Our ref: DOC22/632569

Your ref: SSD-11070211 -MOD 1

Subject: EHG flood comments on a Modification Application – New Public School in Mulgoa Rise – temporary school facilities - Glenmore Park - SSD-11070211-MOD 1

**Figure 1: 1% AEP Flood Depth and Levels**

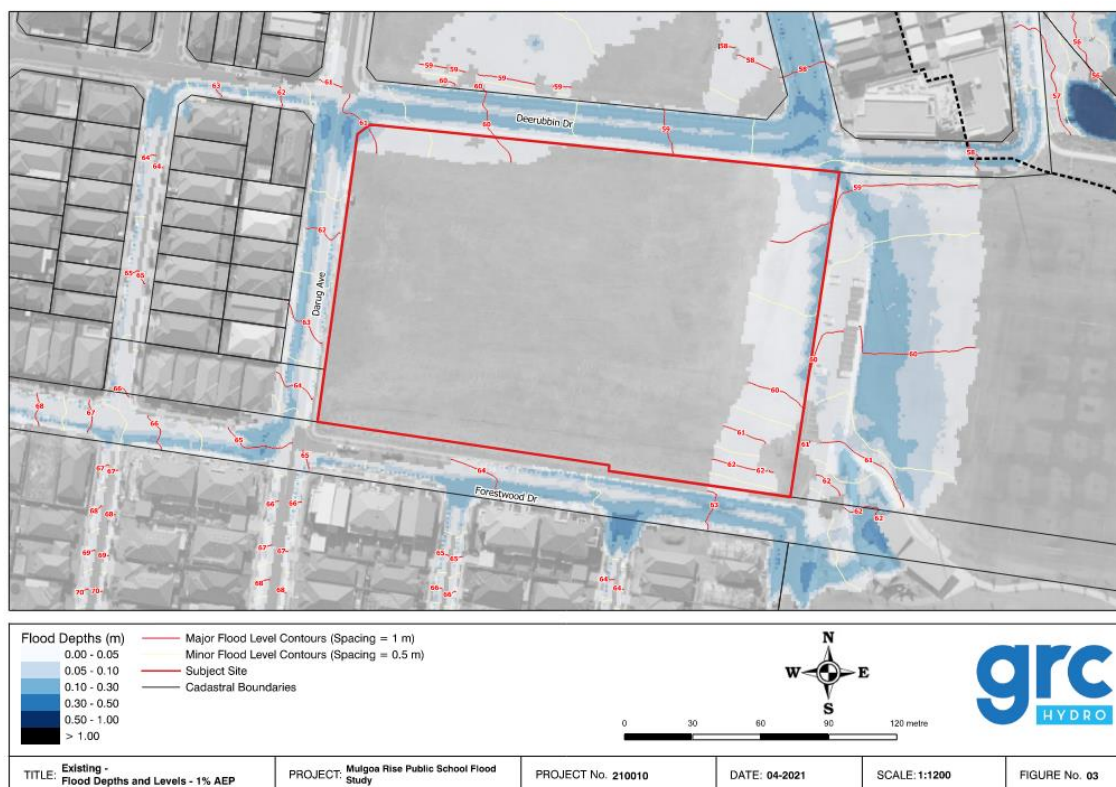
The flood assessment indicates that most of the temporary buildings are located outside of the flood zone. Buildings HB5 and HB4 are partially within the 1% AEP overland flow path at their eastern boundaries. The assessment then recommends that these two buildings will be constructed on piers to allow floodwater in the 1% AEP to flow freely underneath. The habitable level will be 1% AEP plus 0.5m freeboard.

- The whole site of the school, including the area, which is the subject of this modification, is flood prone land i.e., within the extent of the PMF overland flooding.
- EHG requested in October 2021 and December 2021 a review of flood level contours provided in the PMF map as the contour levels are inconsistent with the flood depths shown in the map and the discussion in the report. As a result, EHG is still not sure about the PMF flood level and depth at the site of the proposed temporary facilities.
- The proposed temporary facilities will serve 230 school children ranging from kindergarten through to Year 6. Due to the vulnerability of the development, all proposed demountable facilities must be constructed to withstand overland floodwater for the full range of flooding to ensure they withstand floodwater forces including buoyancy in rarer or extreme flood events.

**Figure 2: Proposed Development.**

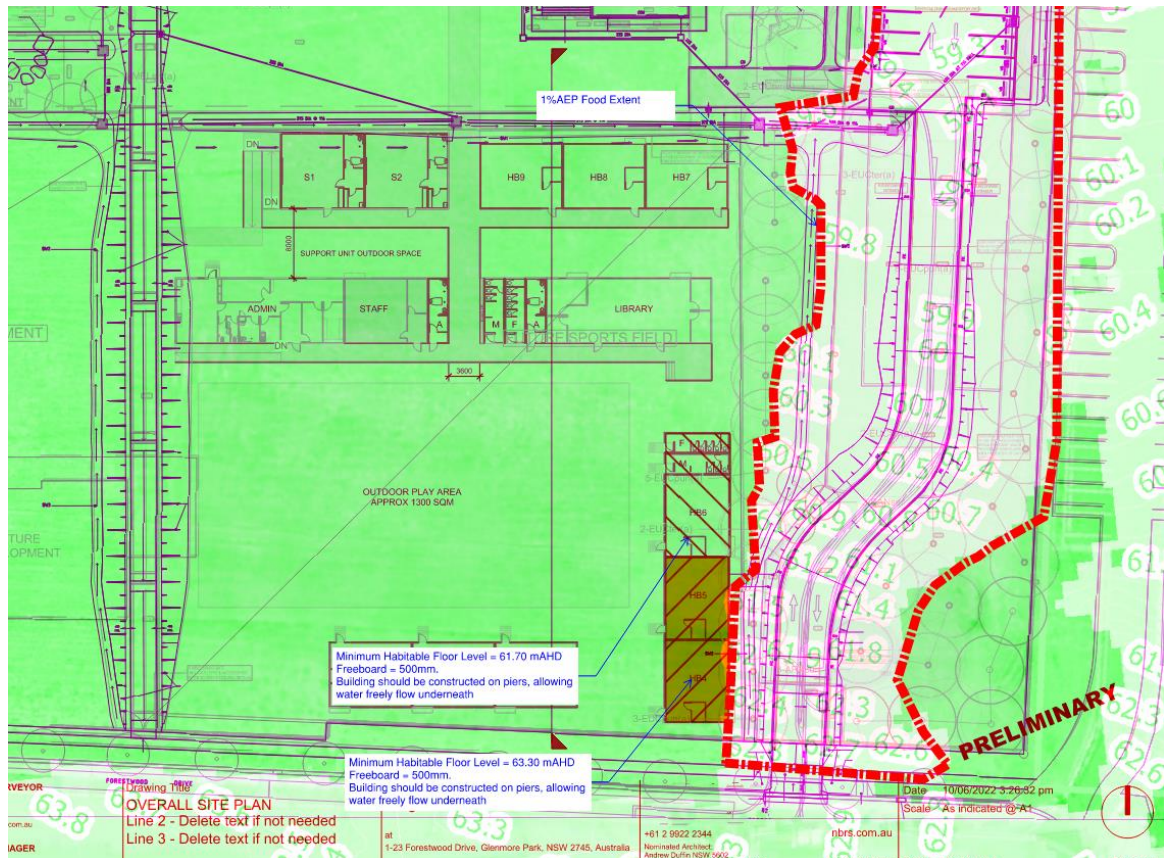
- Emergency management including access to the school and the evacuation of the students from the site in rarer flood events should be considered. School children should not stay in the facilities during floods larger than the 1% AEP. Buildings HB5 and HB4 must evacuate to other buildings if constructed on piers as they would be subject to isolation in the 1% AEP or larger flood events.
